249 BANCROFT RD, PORTLAND

ADDITIONAL INFORMATION REQUESTED:

PARTITION WALL  
MATERIAL:  
2' x 8' SPRUCE  
1/2" MOLD-RESISTANT  
SHEET ROCK

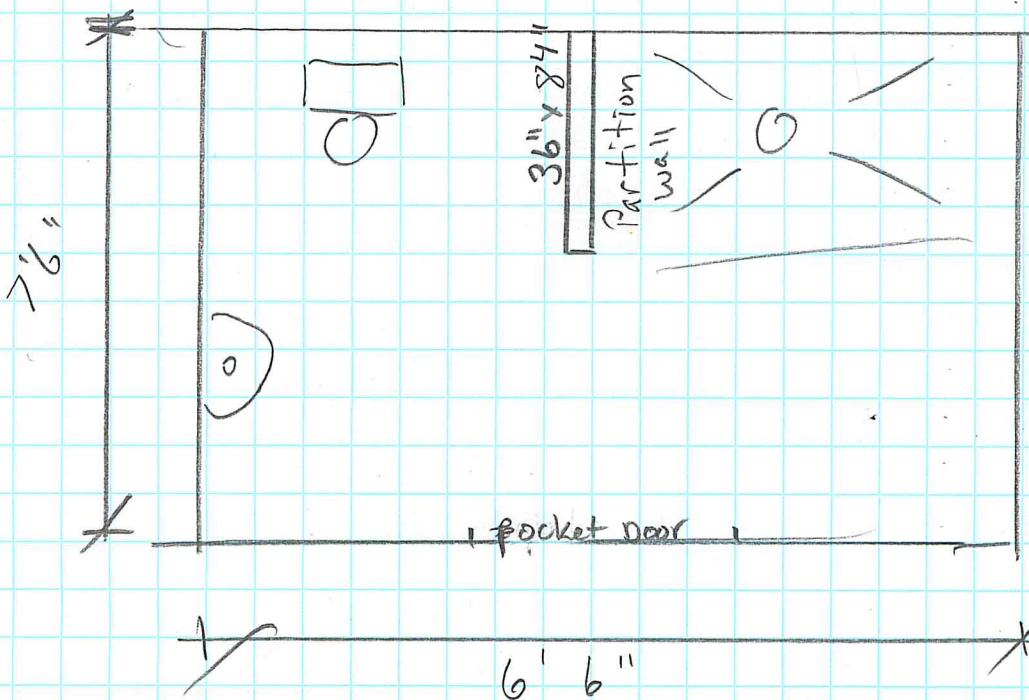
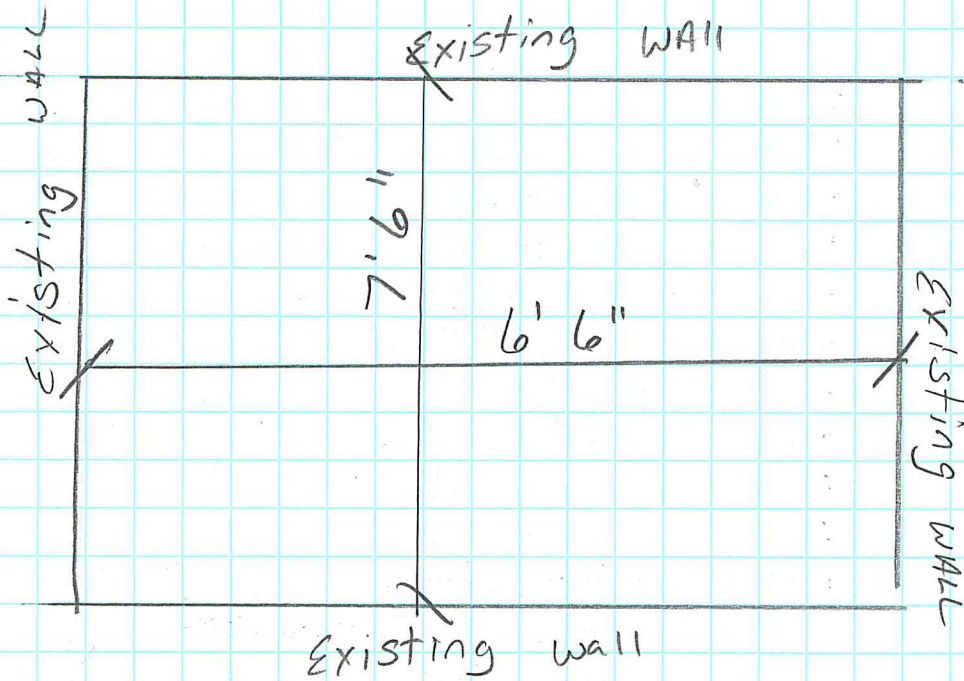
. Do the bathroom walls already exist or are you creating new walls for the bathroom? If you are adding new walls, please submit the framing plans for your bathroom so that the reviewer can see how you plan to construct the walls.

Bathroom walls do exist

Creating a 36" x 84" partition wall for one side of the new walk-in shower. (drawing attached)

Basement Bathroom

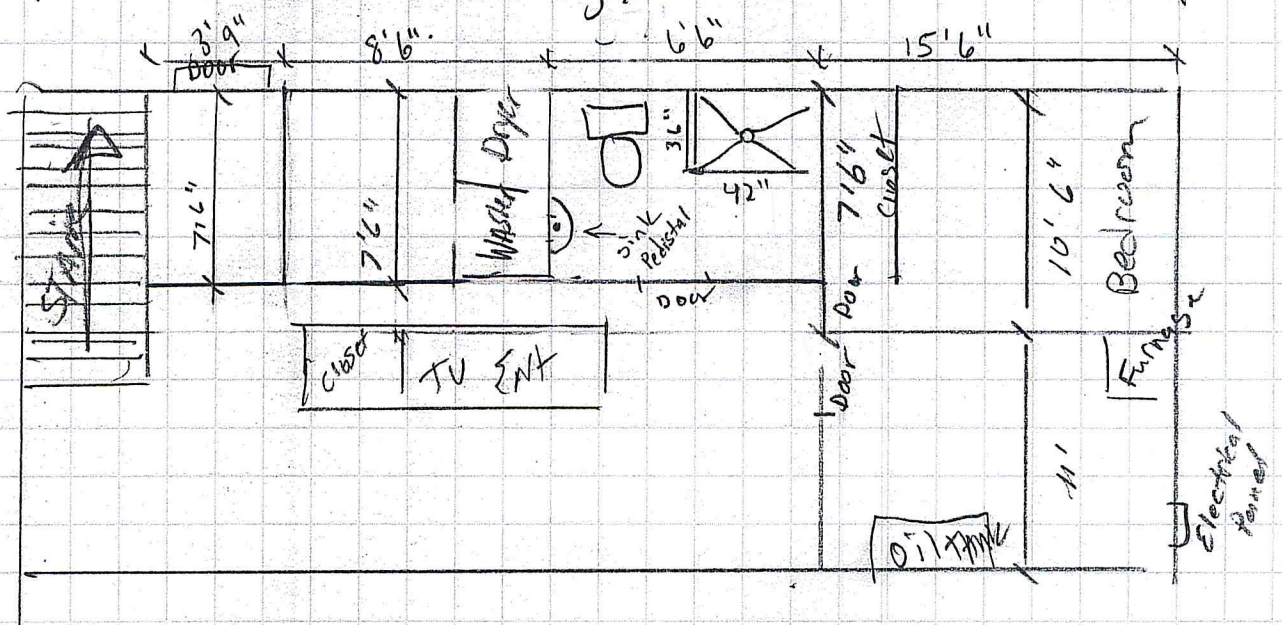
Please detail how you will attach the hanging ceiling and where you are installing the new lighting fixtures.

Please provide information about the bathroom pocket door and the type of hung ceiling you plan to install

18" gauge hanger wire

Eye-lag screws for wood joist (1/2" x 3")

Armstrong hemmed angle for walls

Armstrong 2' cross tee

2' x 2' Armstrong ceiling tile

Lighting Fixtures

Two sconce lights over pedestal sink (one on each side of mirror)

One fan/light combination in center of ceiling (Panasonic FV11VQI6)

Vented outside with 4" round metal duct pipe-6' long to exterior of house.

Pocket Door-2' x 4' existing none weight bearing wall

Installing a 2/8 x 6/8 6-panel wood door with Everbuilt 36" adjust pocket door frame set

Hung ceiling

Armstrong drop ceiling
